RFI

RFI #: 161
Date: 6/25/2012
Job: EB-02 Keller Springs Lofts
Phone: 877-777-5115

Subject: Electrical Outlets Moved for Code

**E-2.1**

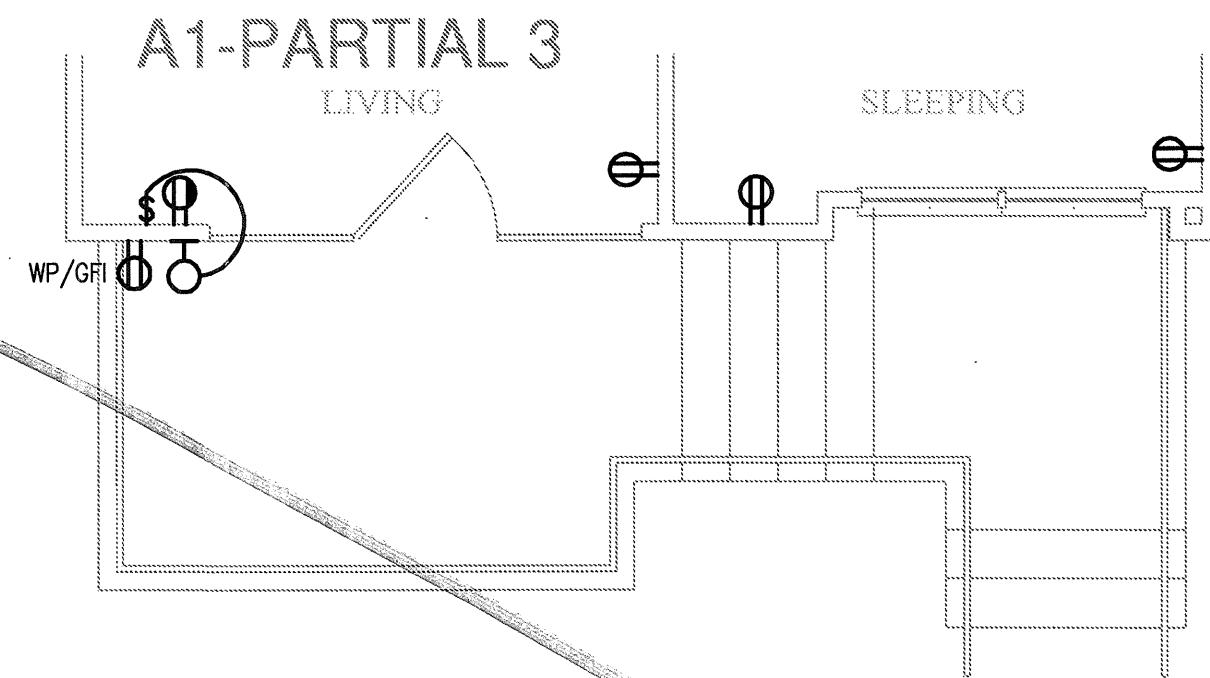
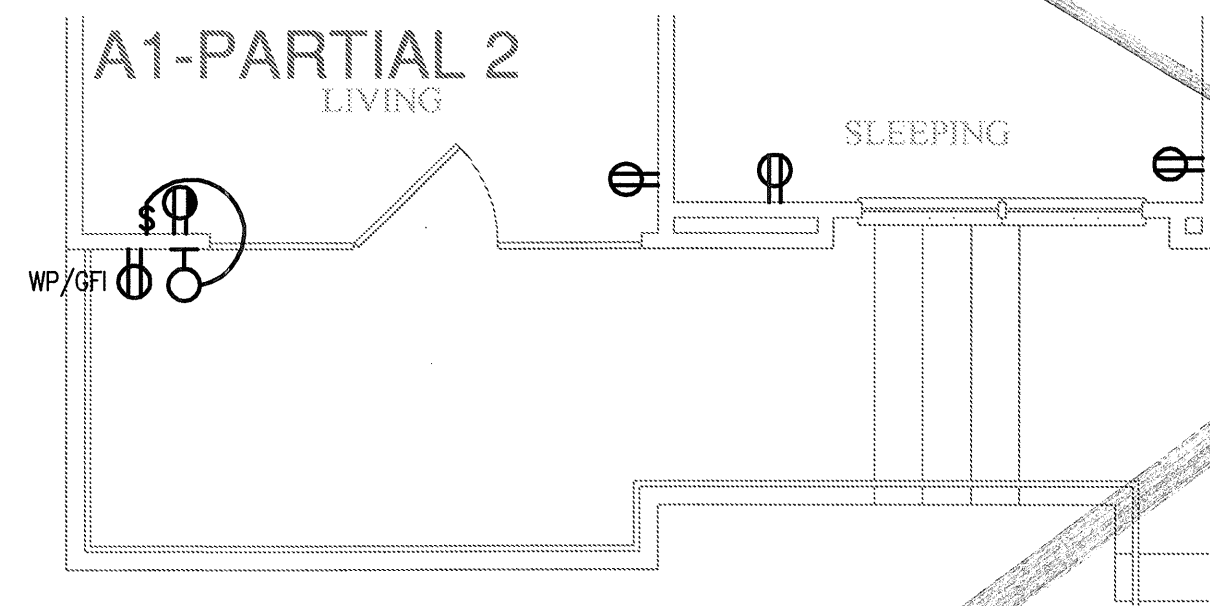
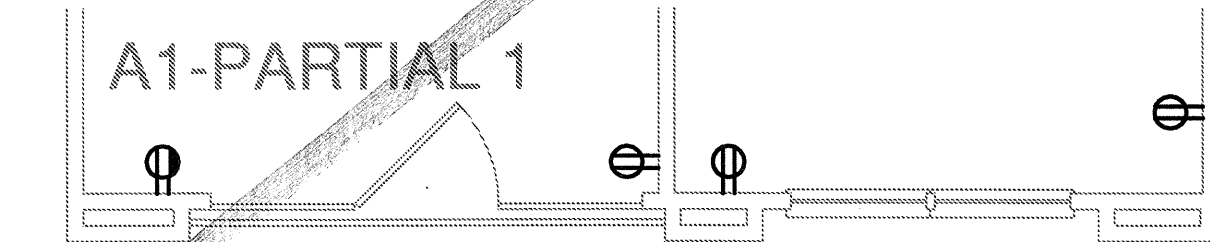
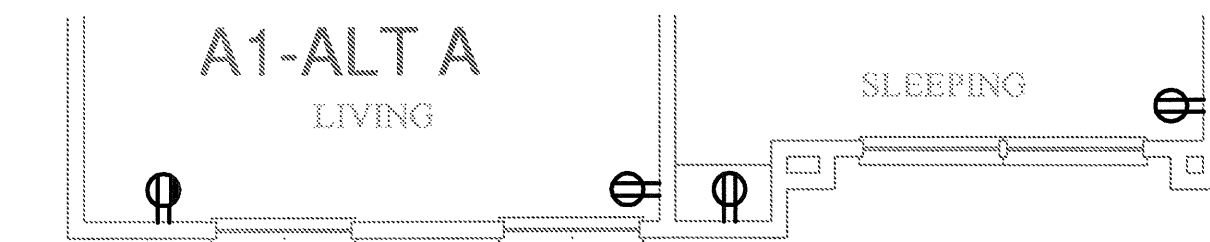
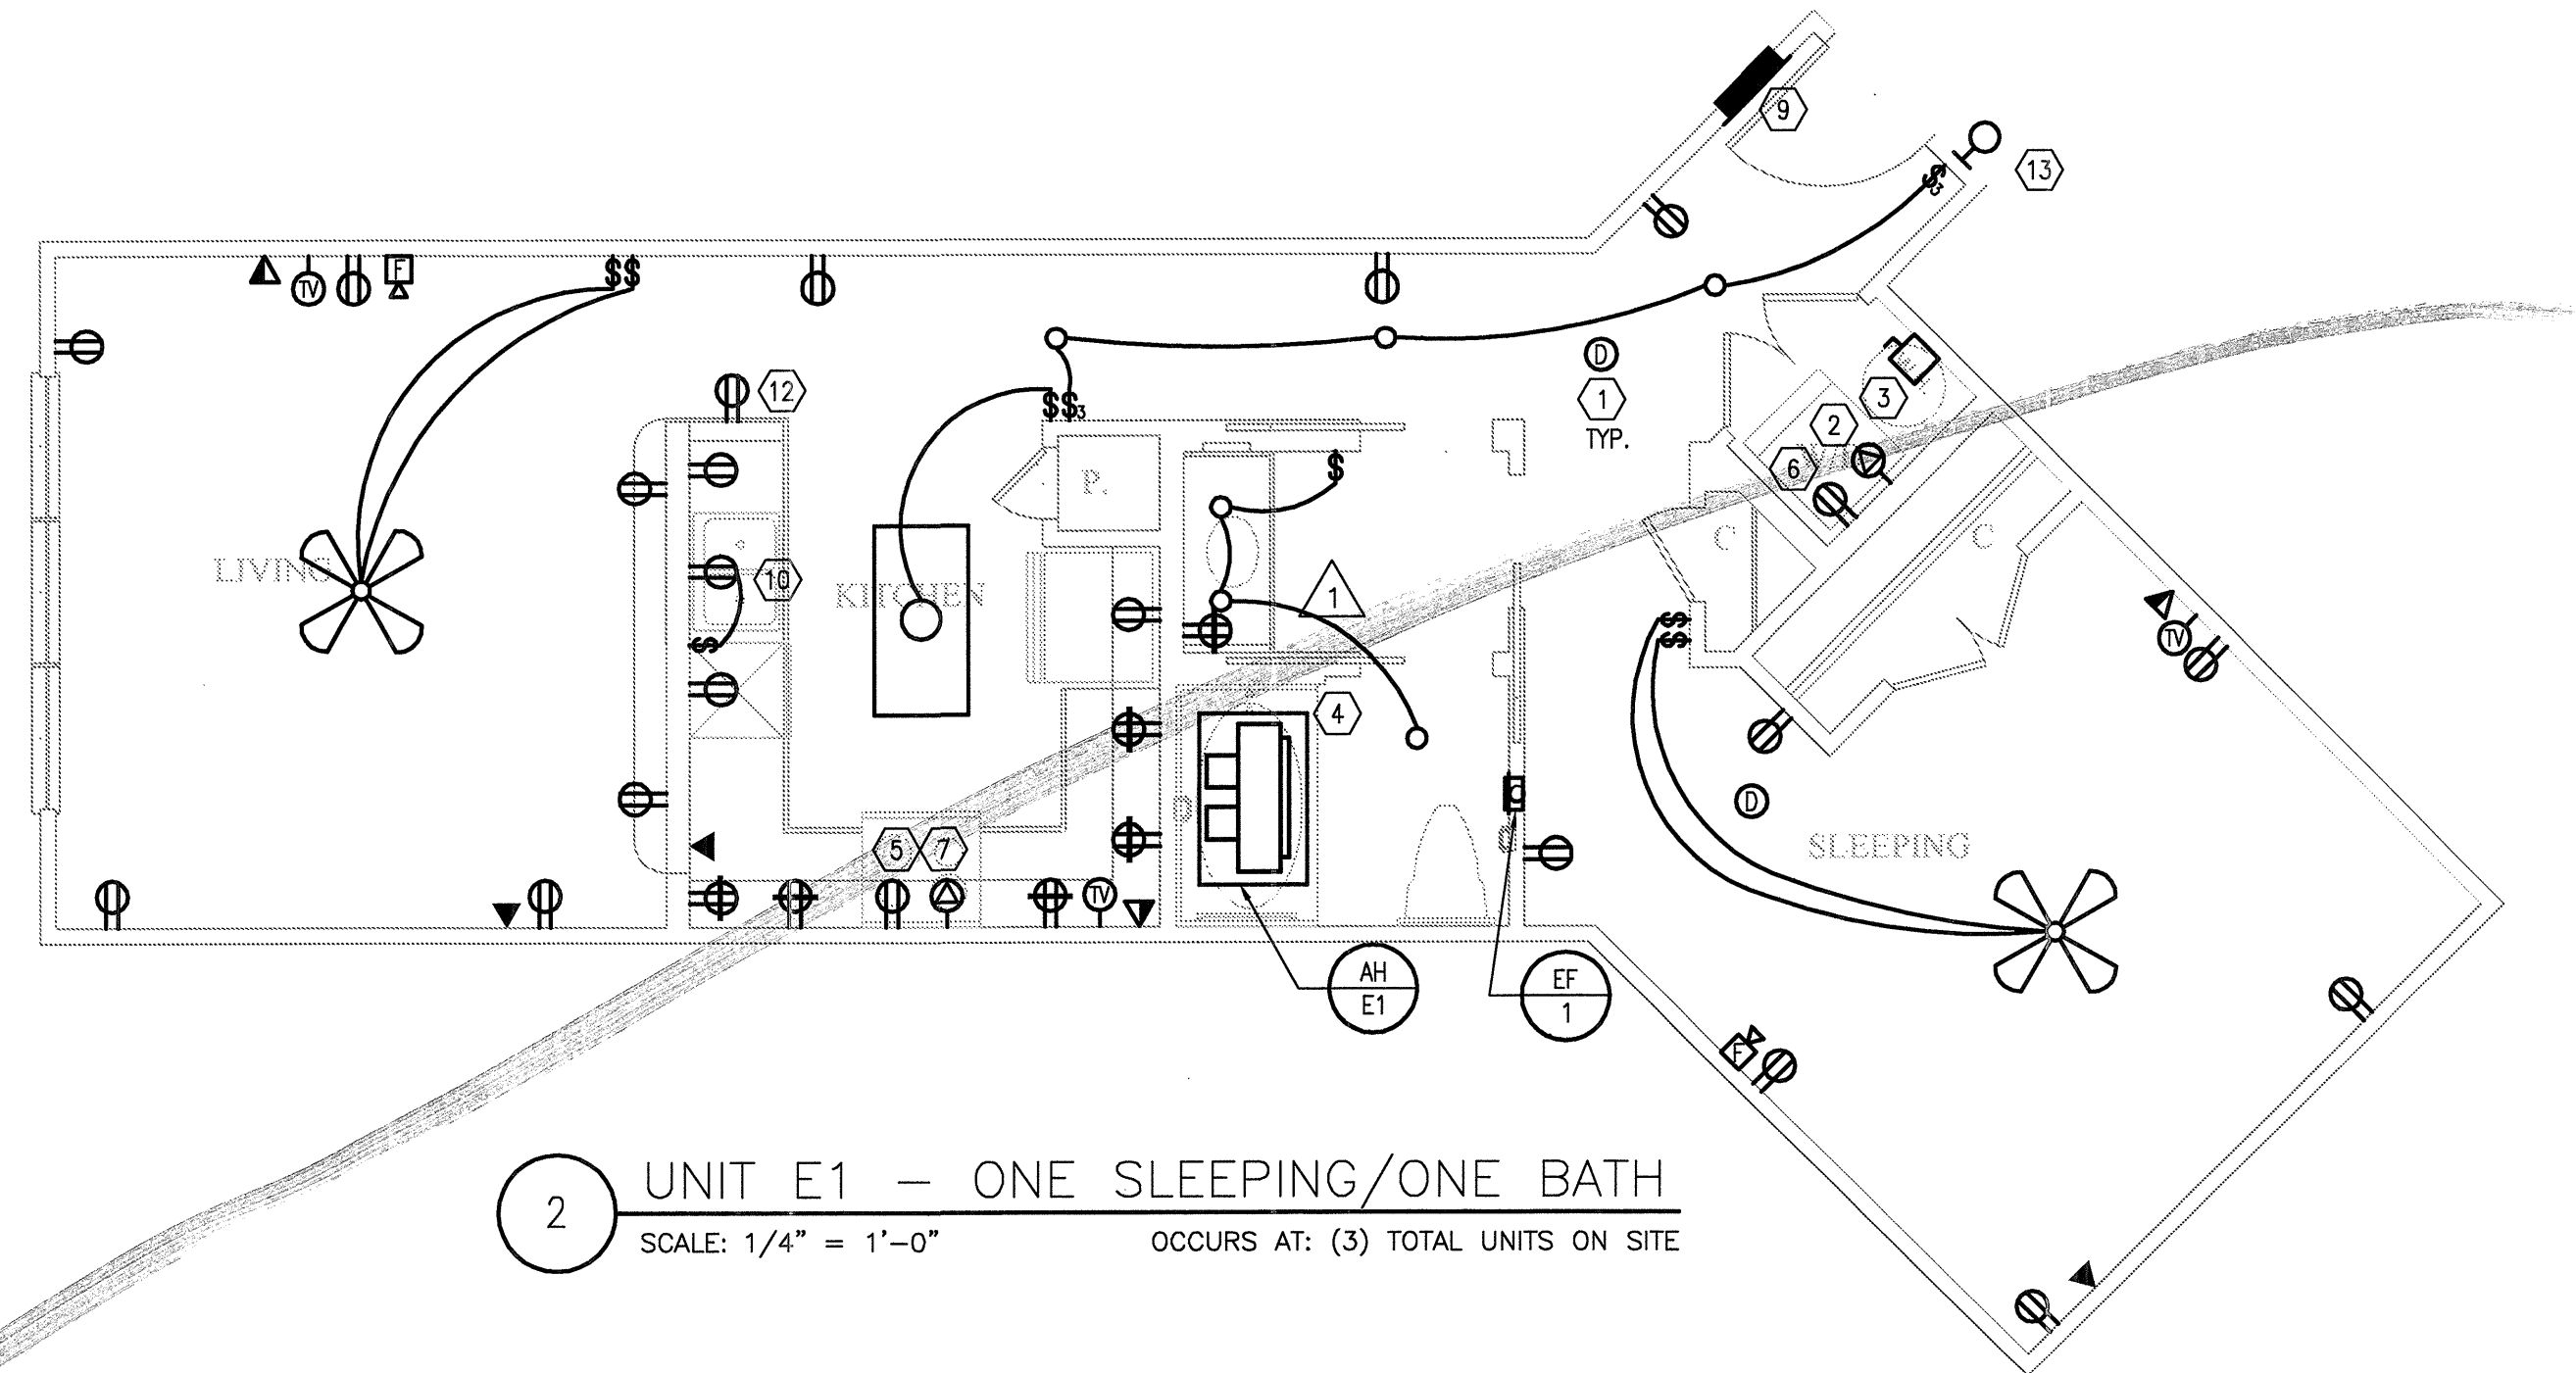
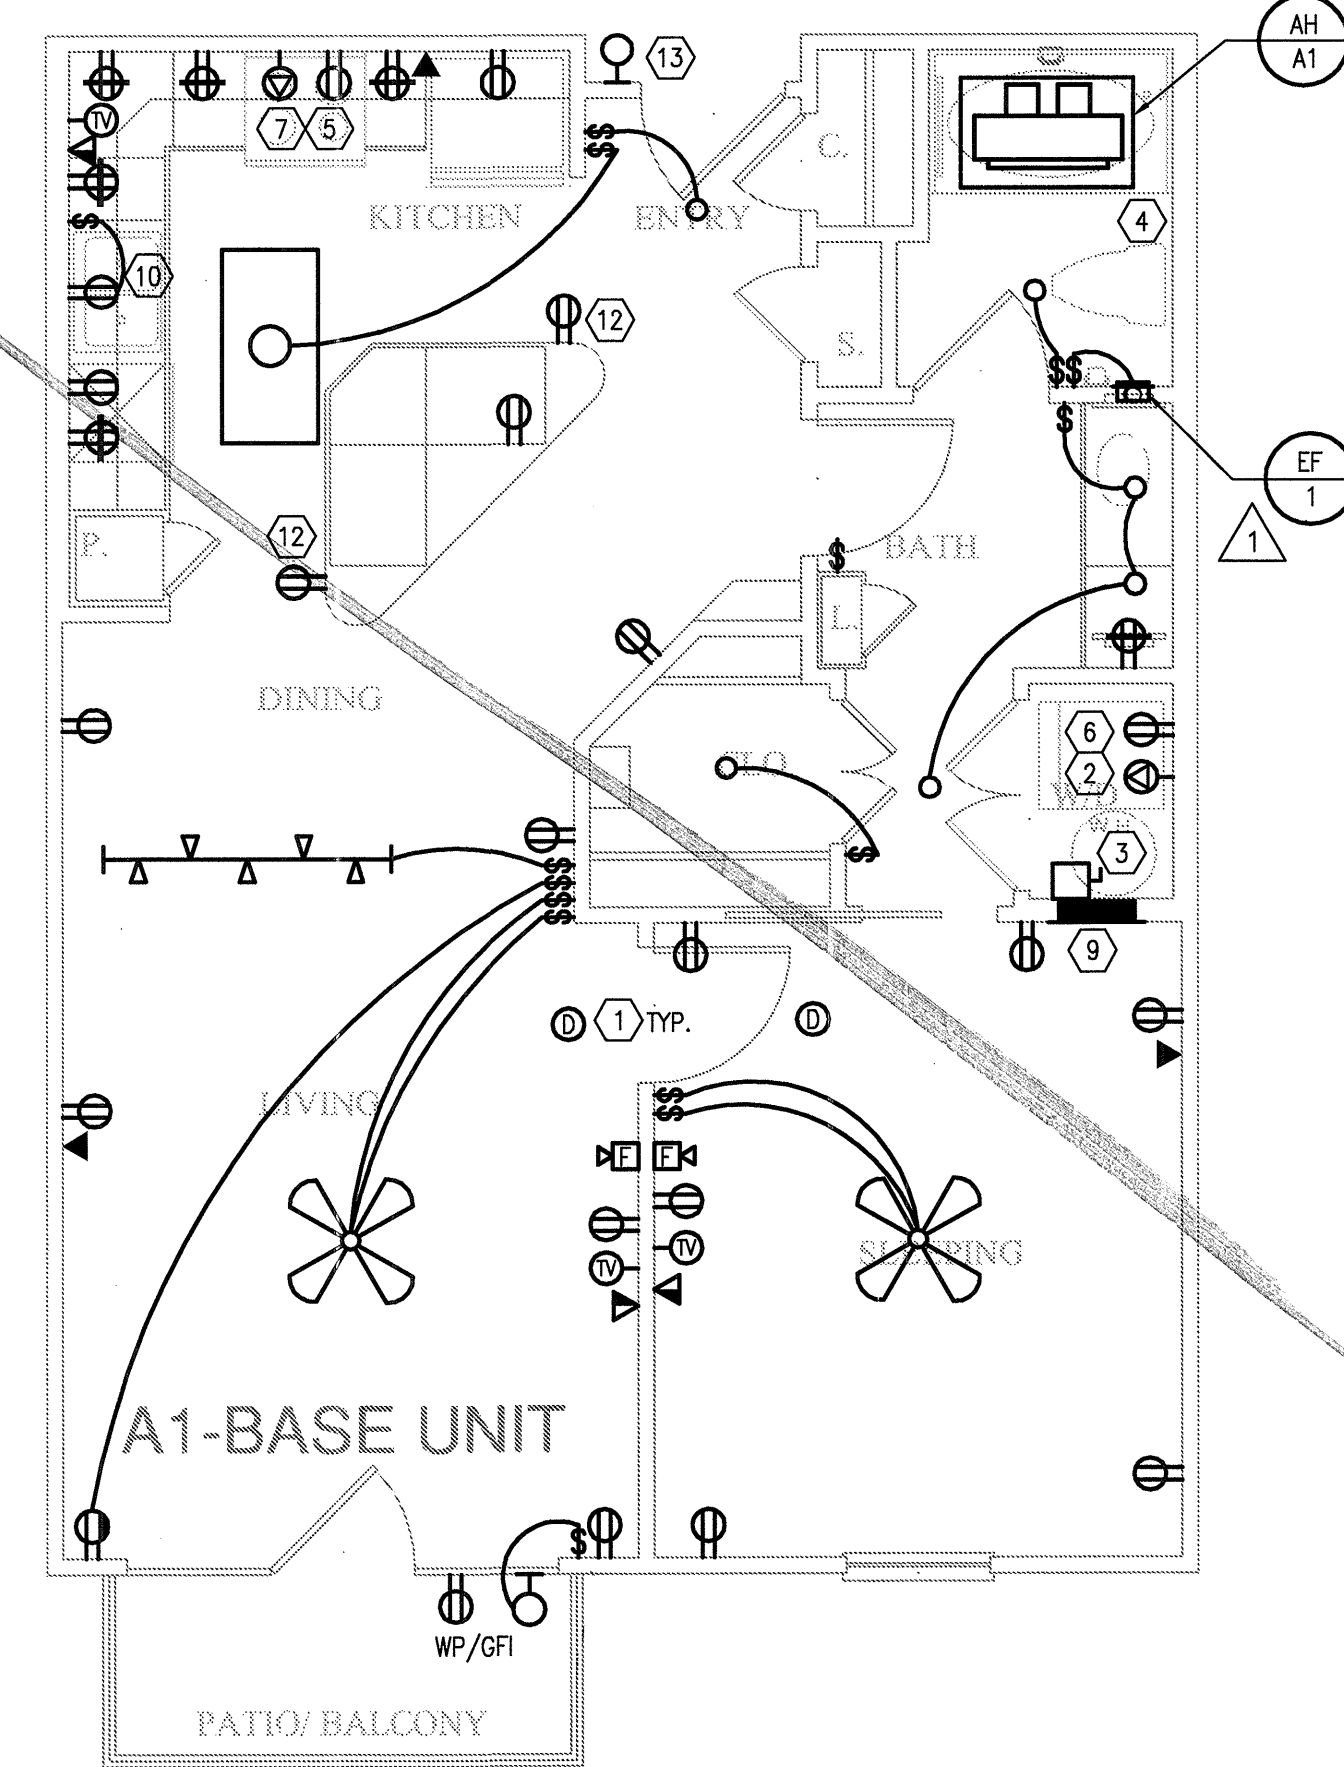
Request: We had an issue at another job where some receptacles needed to be moved in bathrooms due to code. Please check and see if this issue will need to be addressed at this job and revise plans if needed. **Date Required:** 6/26/2012

Reference the attached pdf's showing the correct outlet locations.
